COUNTY OF HARNETT LAND USE APPLICATION

Zoning: RA-20R Subdivision: Crestview Estates Ph 5 Lot #: 253 Lot Size: .35 ac

**RE: Harnett County Land Use Application HTE# 07-5-17983 Lt#254 Crestview Est.
THE# 07-5-17982 Lt#253 Crestview Est.**

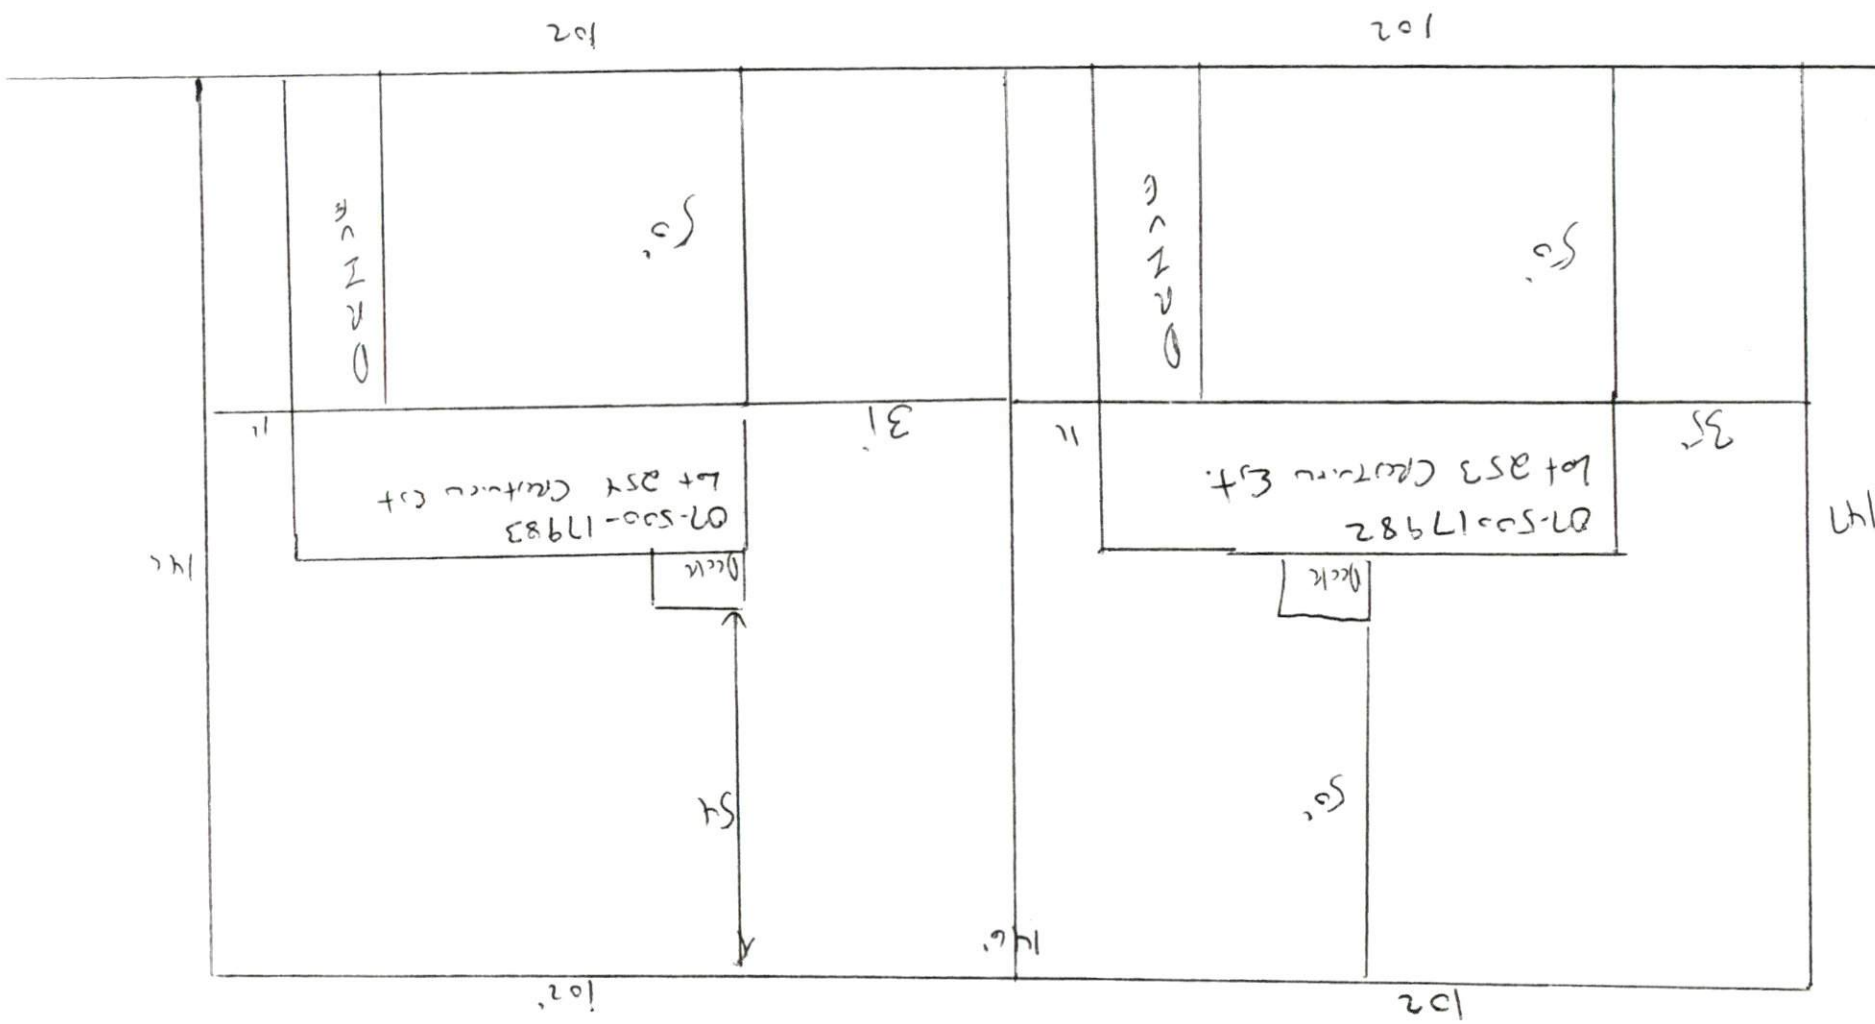
- 1. Property lines/corners not marked or labeled
- 2. House corners not marked or labeled
- 3. Directions not clear to property
- 4. Property needs brush or vegetation removed
- 5. Backhoe pits required
- 6. Other *Please move house location as shown on attached sheet and submit new plot plan with changes to Central Permitting.*
